**Our Ref** 7521-UA001881-01  
**Your Ref**  
**Direct Line** 029 2092 6812  
**E-Mail** michael.pearson@hyderconsulting.com

**North West Bicester Eco-Town, Oxfordshire  
OCC Planning Comments**

Thank you for considering and responding to the planning application for the first phase of the NW Bicester Eco-town, Oxfordshire. This letter contains further information requested within your response in relation to drainage and street lighting aspects.

Title  
EXEMPLAR SITE  
TYPICAL  
WATER COURSE CROSSING  
GENERAL ARRANGEMENT

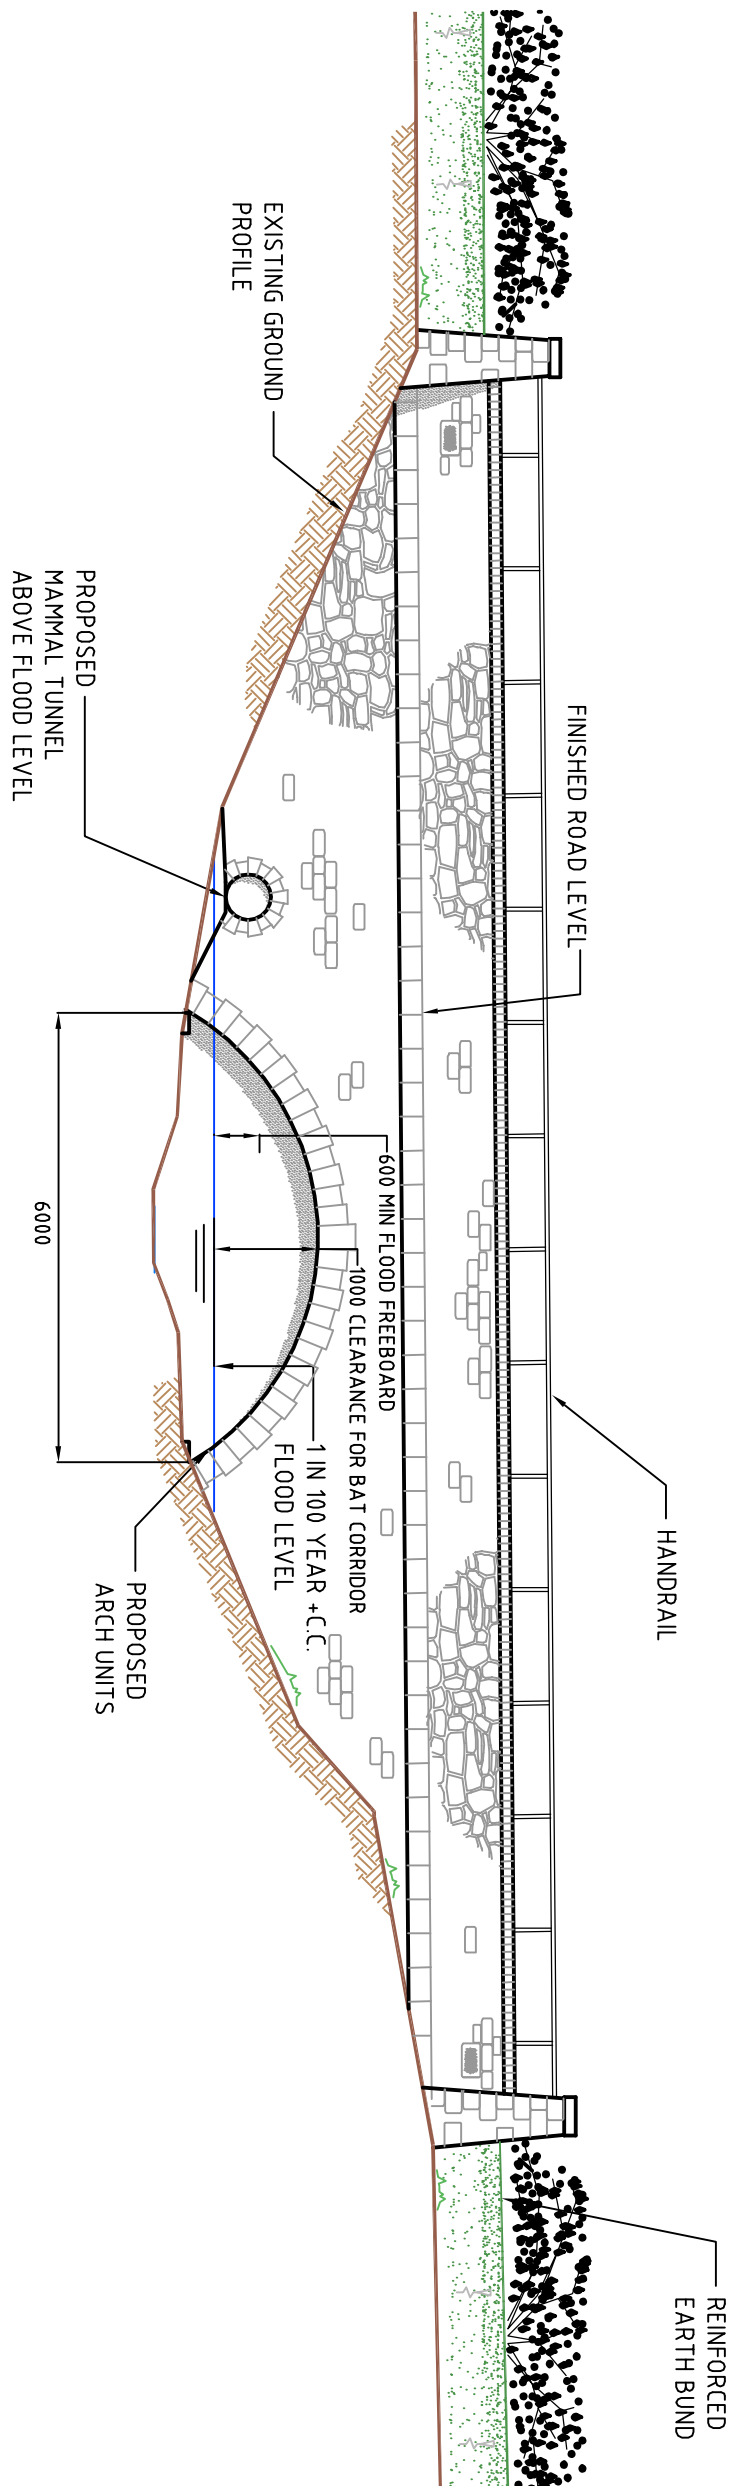
- Drg 7153 - No drainage shown on road narrowing on bridge;  
*Drainage will be provided for all engineered areas of the site. The bridge is covered by the drainage strategy as part of the road network and will be designed to include an appropriate positive drainage system connecting to the adjacent road drainage.*
